STATE OF NORTH CAROLINA
DEPARTMENT OF TRANSPORTATION

SUBJECT: Request for Modification of the Phased Section 404 Individual Permit and Section 401 Individual Water Quality Certification, Neuse River Riparian Buffer Authorization for the construction of the Triangle Expressway Southeast Extension from NC-55 Bypass in Apex to I-40, Wake and Johnston Counties. TIP Nos.: R-2721, R-2828, and R-2829. Federal Aid Project No. 0540047.

We are requesting a modification to Section 404 Authorization (SAW-2019-02240) and the associated 401 Individual Water Quality Certification (Permit No. 20181249). This request is prompted by the Design-Build Team identifying an opportunity to reduce the overall length of the Neuse River Bridge by approximately 290 feet while maintaining the FEMA and NC Floodplain Mapping “no-rise” condition at Sites 14 and 15. This has numerous benefits that are described in further detail below. It is estimated that the construction cost savings to the project by reducing the length of the Neuse River Bridge is on the order of \$2 million.

SITE 15

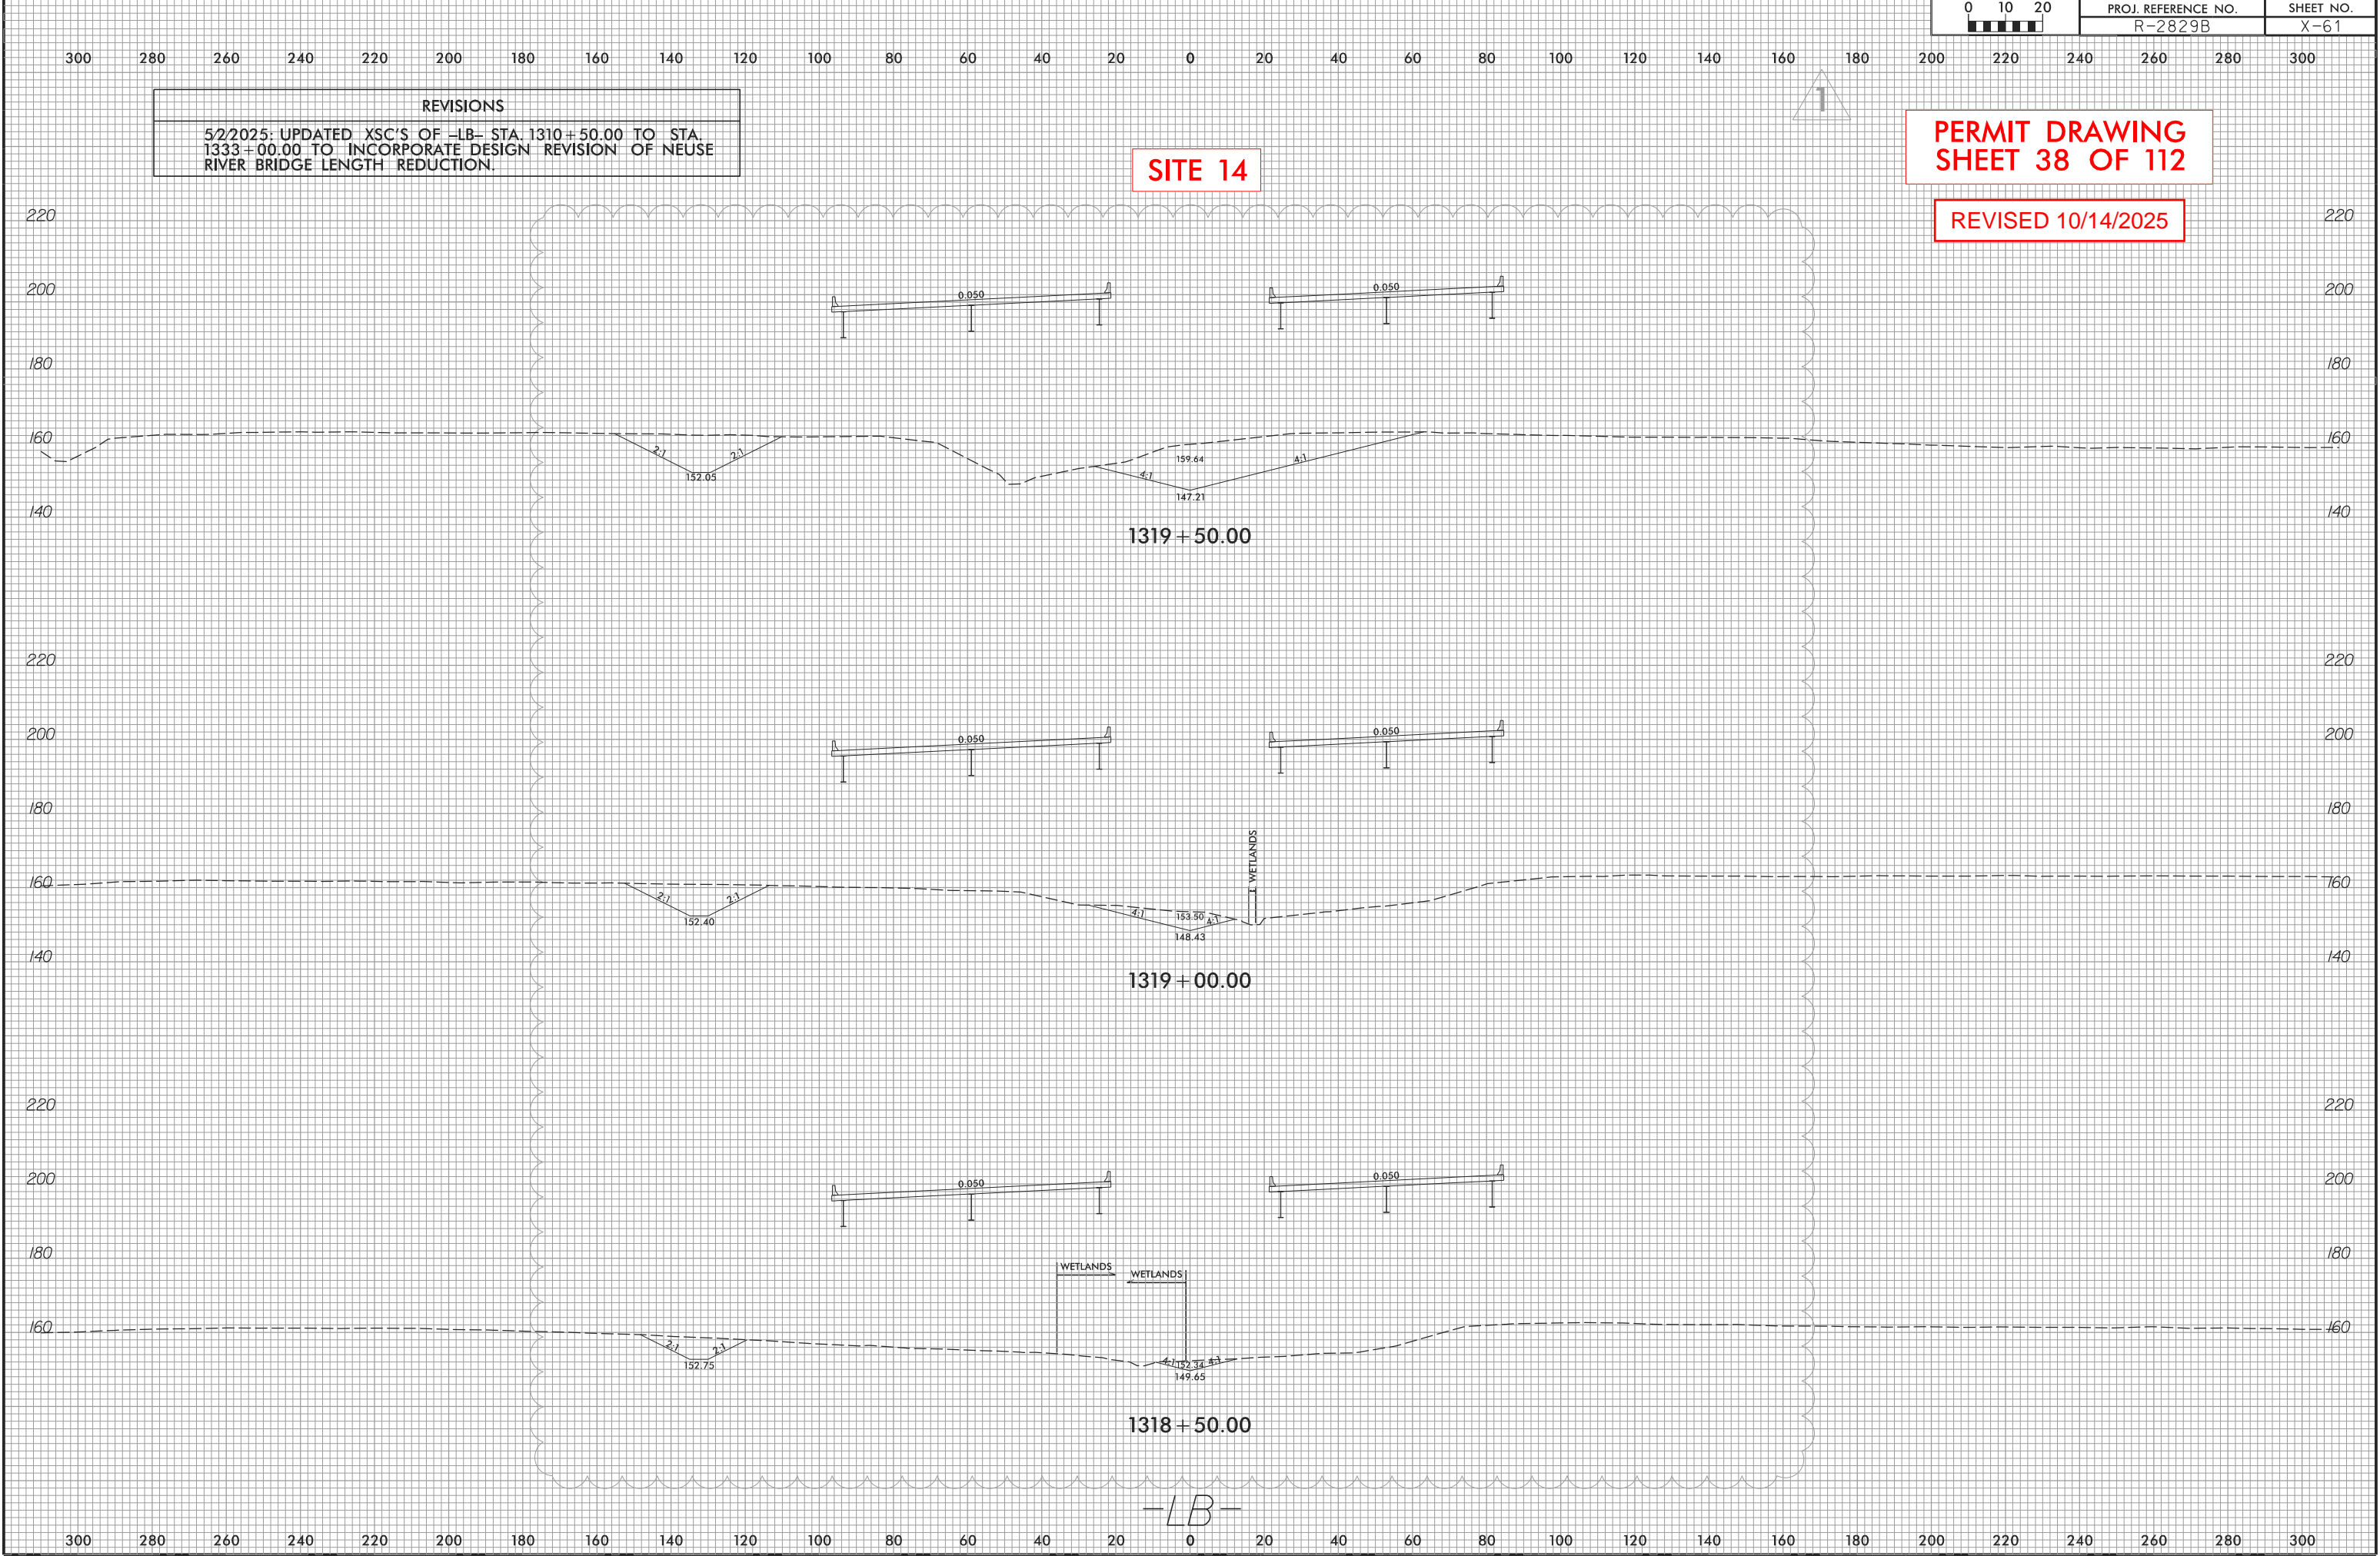
Site 15: Neuse River (-LB- 1319+95 TO 1321+83 M - BANK STABILIZATION)

- Permanent Stream Impact: 51 lf (previously 76 lf – decrease of 25 lf)
- Temporary Stream Impact: 73 lf (previously 108 lf – decrease of 35 lf)

The elimination of a lateral base ditch results in a reduction of bank stabilization impacts to the Neuse River where the ditch previously tied in.
